CITY OF ALBUQUERQUE

October 5, 2022

**RE: Office/Warehouse at
3831 Masthead St NE
Grading and Drainage Plan
Engineer's Stamp Date: 8/29/22
Hydrology File: D17D095A**

CONCEPTUAL GRADING
AND DRAINAGE PLAN

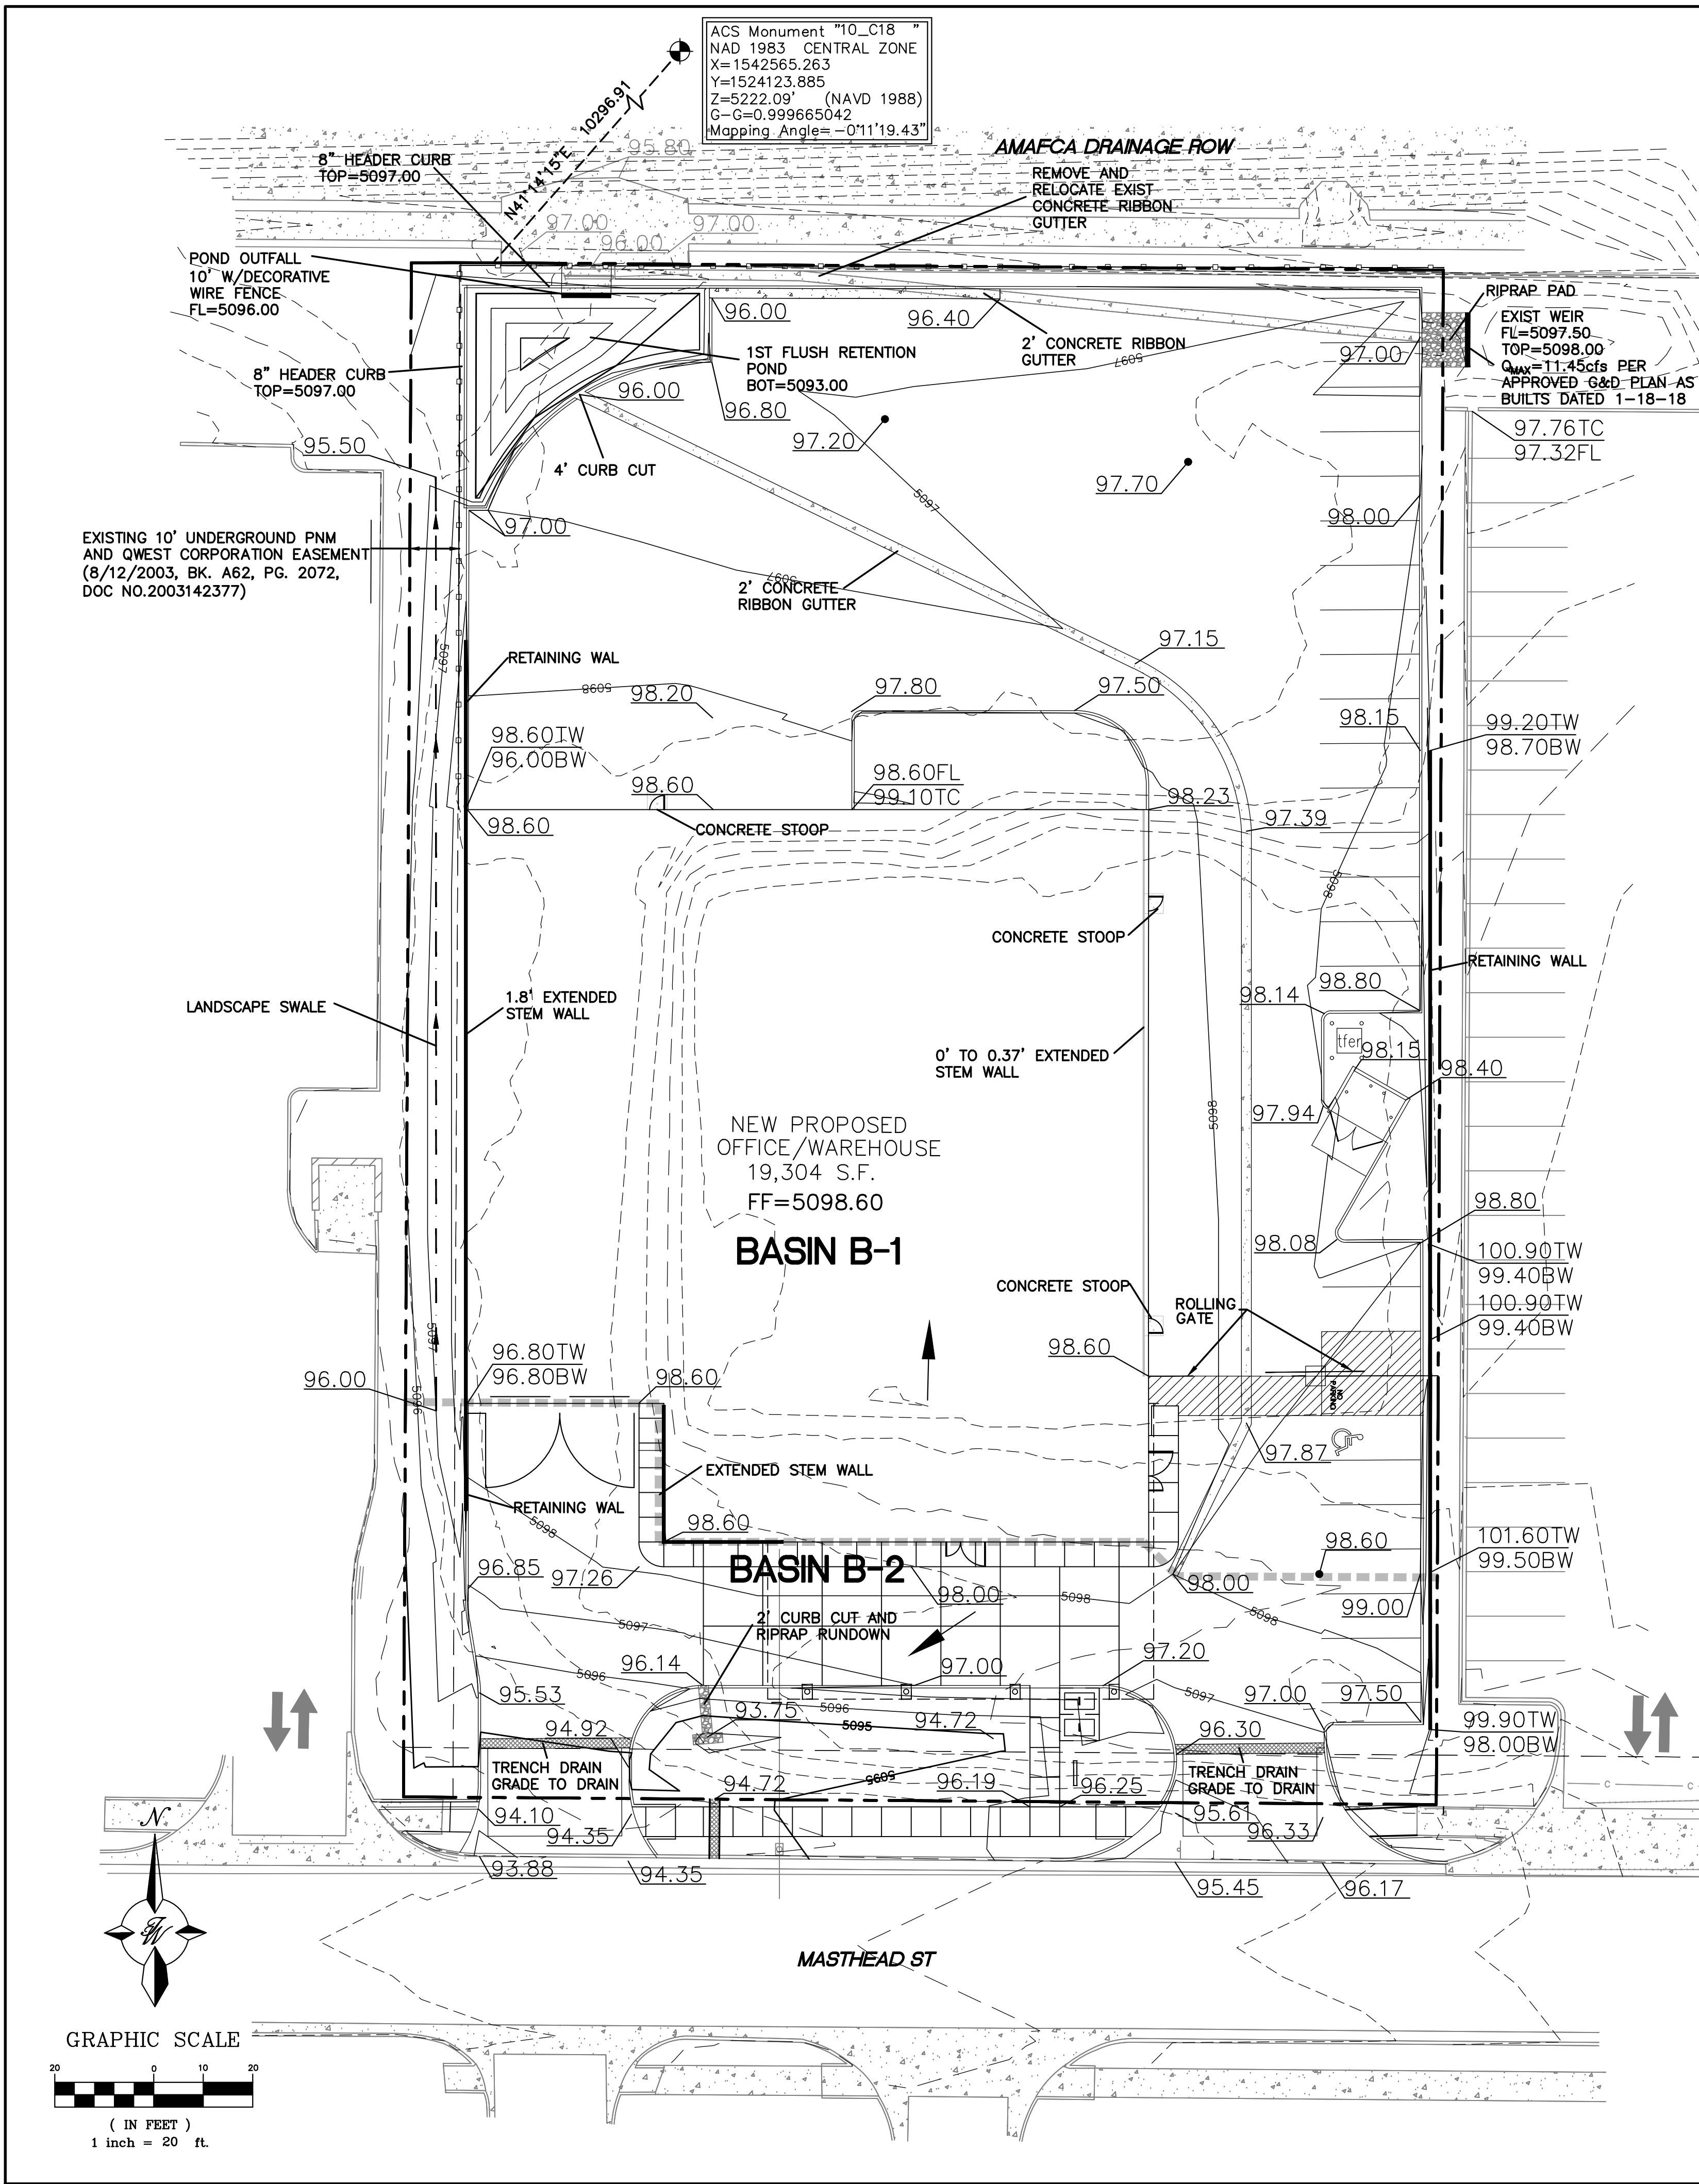
3. Identify the offsite basin that flows through the North Pond and provide hydraulic capacity calculations and construction details of the pond inlet and outlet structures.

4. The location of the South Pond isn't clearly identified with top and bottom elevations. It appears that only a small fraction of Basin B-2 flows into the South Pond and the rest of it drains to Masthead St through the driveways. Add drainage structures to get more of Basin B-2 into the south pond. Identify the location South Pond spillway and add a construction detail.

5. Existing grades are missing and must be shown on the plan, especially at the perimeter of the property where proposed grading must match existing grades. Also provide proposed contours.

6. Please provide the Benchmark information (location, description and elevation) for the survey contour information provided.
7. Provide sections through all external boundaries showing proposed retaining walls, garden walls, property/ROW lines, existing and proposed grades. In accordance with DPM Ch.22, section 5 part B, grading and wall construction near the property line may not endanger adjacent property or constrain its use.
